Application No: M/47/21/HH
Site Address: 22 Tudor Close Middleton-On-Sea PO22 6DN
Description of works: Removal of existing roof structure, new first floor accommodation and pitched roof above and replacement rear two storey extension and new front porch extension.

Thank you for your internet representation made on 5th May 2021 which has been recorded as an objection with the comments as follows:

PROPOSED FIRST FLOOR PLAN

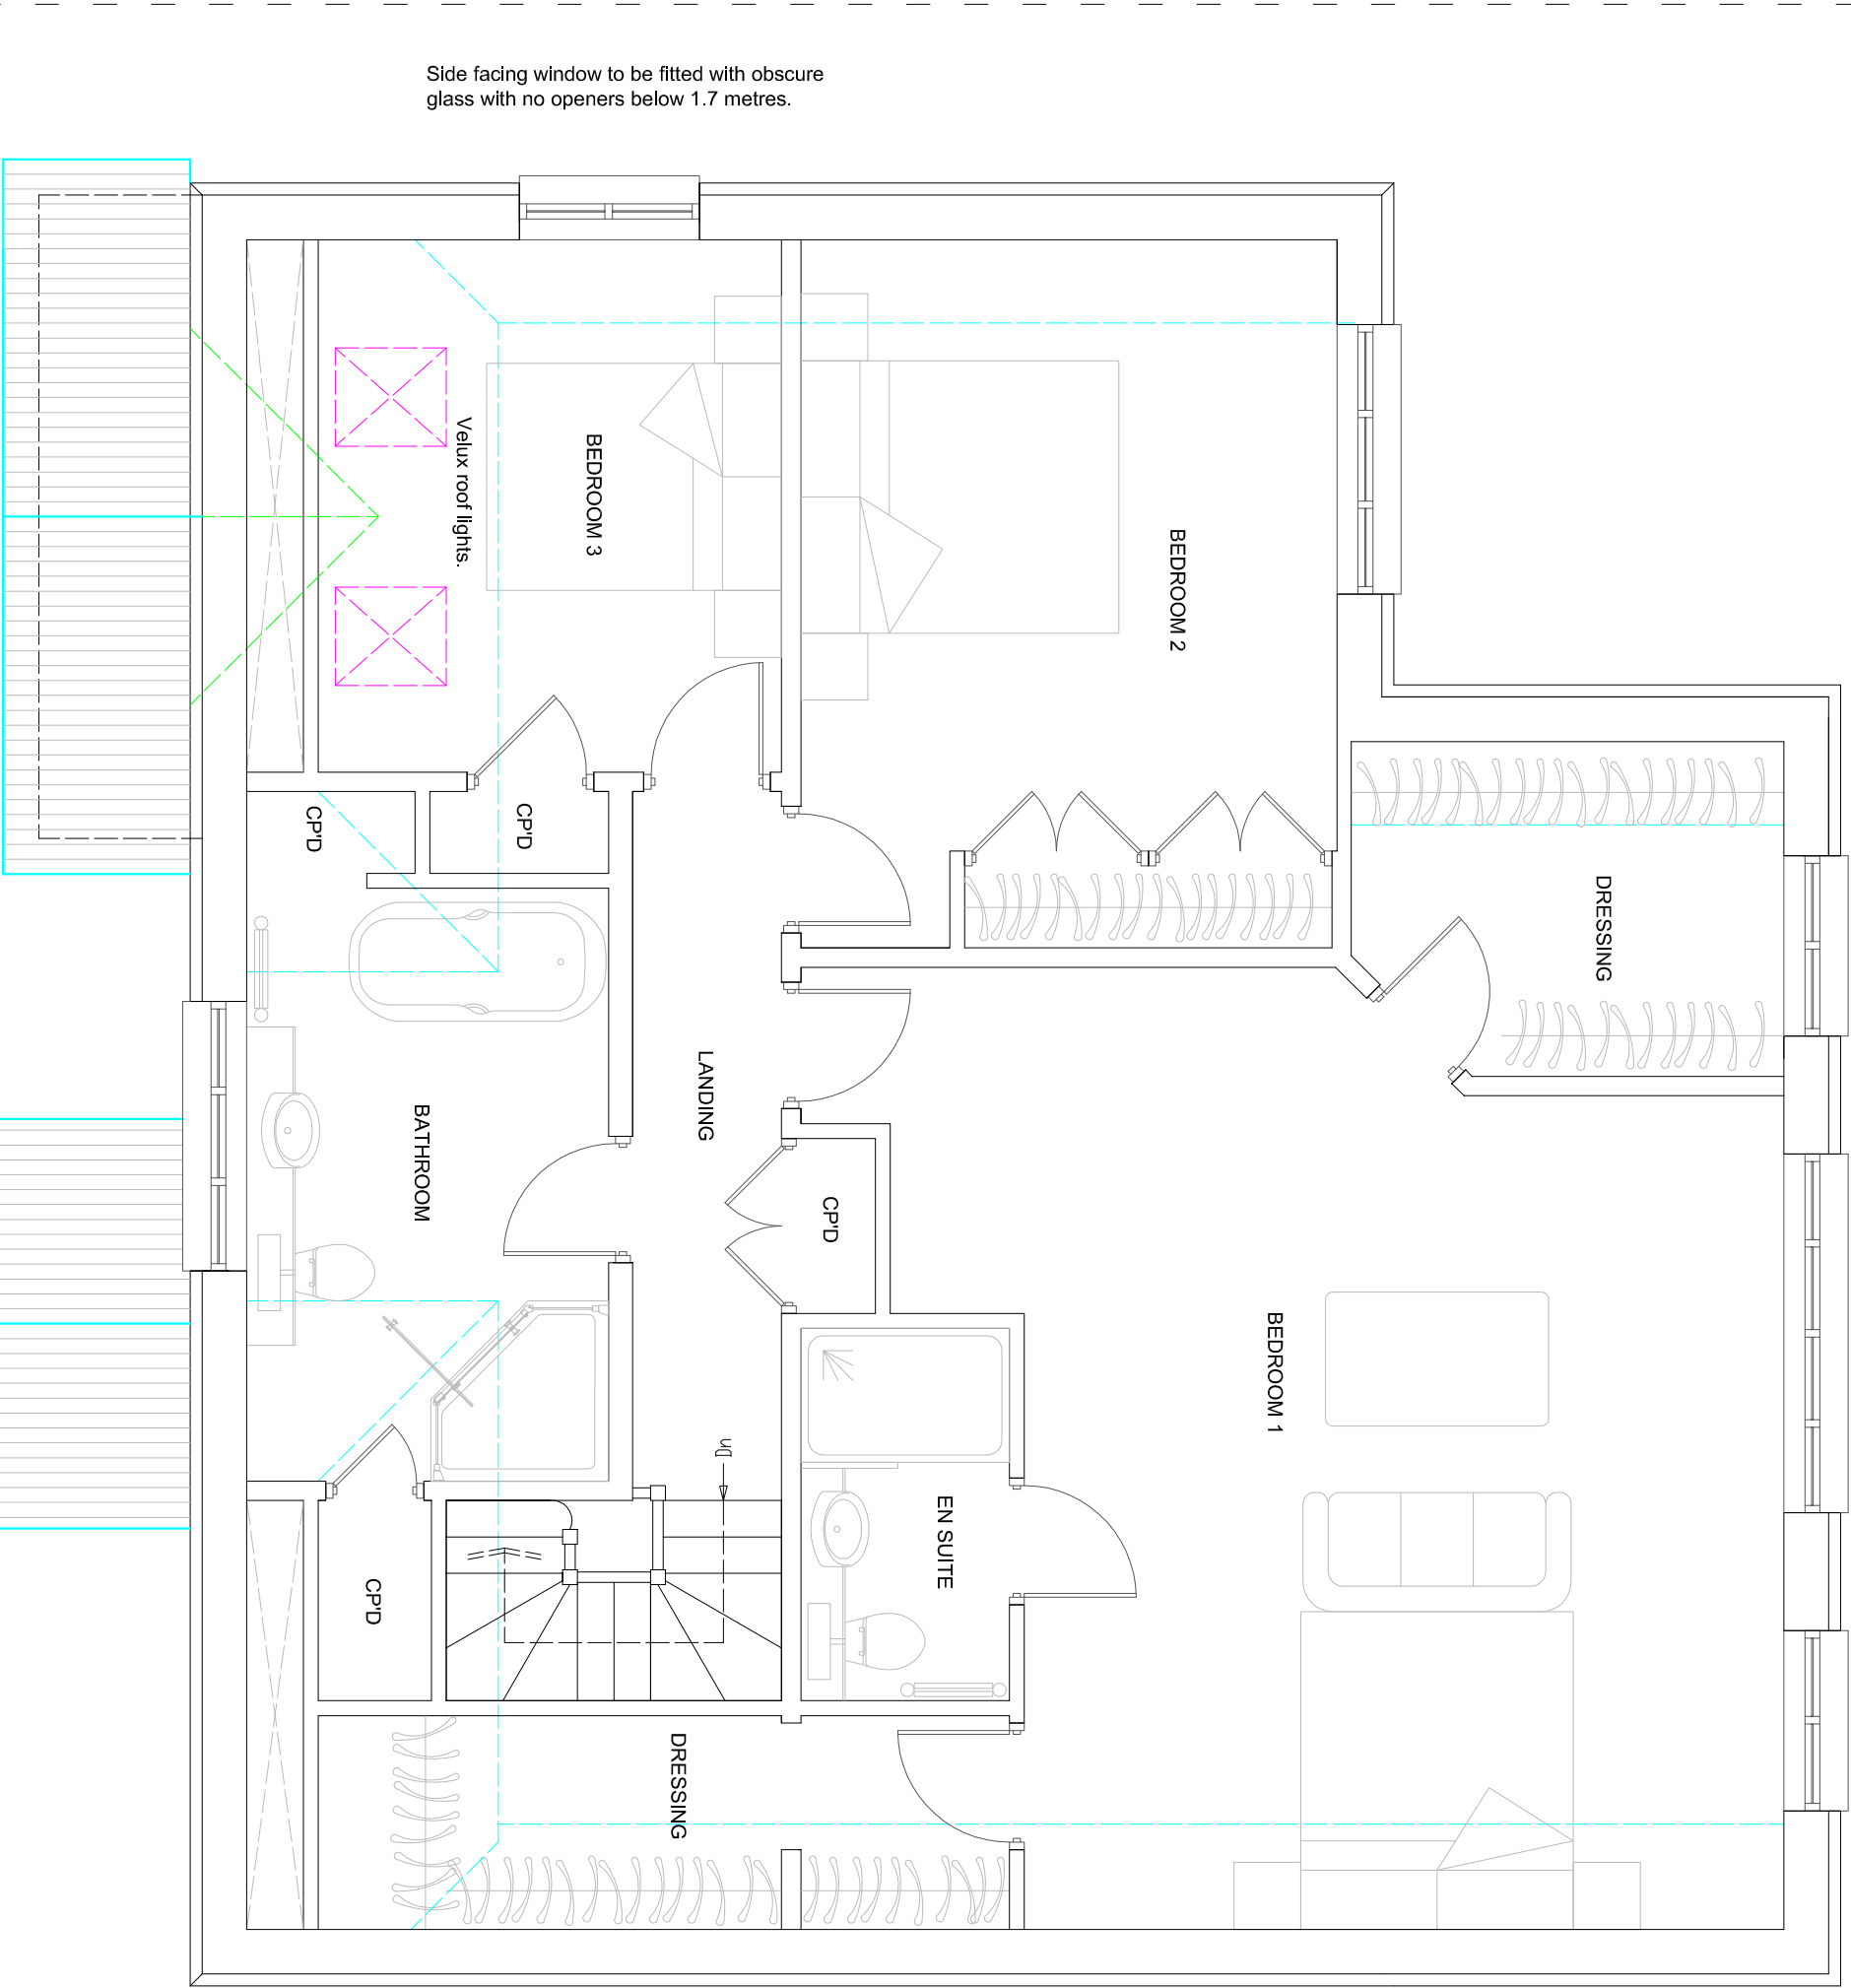
*Neighbours will look into 2 bedrooms and a dressing room, not obscured. The vast size of the master bedroom windows will create a loss of privacy for No 22 and ourselves. With the bedroom lights on half of the house will be lit up creating significant visual intrusion for neighbouring houses.

REAR ELEVATION

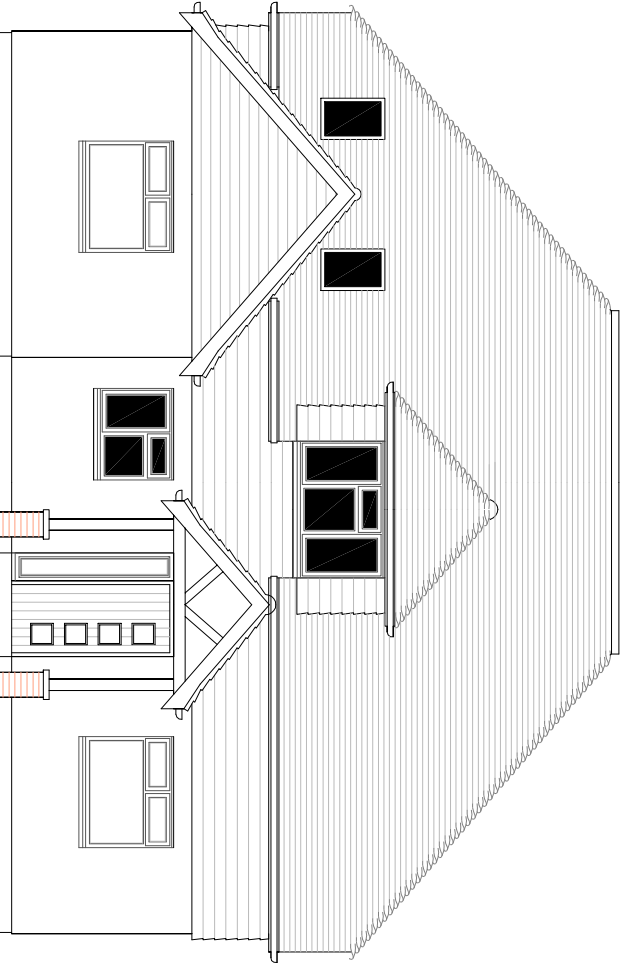
*The increase in size and number of windows on the first floor rear elevation are disproportionate to the original building and not in keeping with the character of the house. They will span more than 6.50m

*The current design and excessive mass to the rear means that the bank of windows will be visible from the properties to the south and from the southern most pavement of Middleton Road.

*Guidance suggests using low roof lines and smaller scale dormer windows with 1st floor living accommodation within or partially within the roof space. Whilst this has been achieved in the front of the house there is no attempt to have the same level of design to the rear.
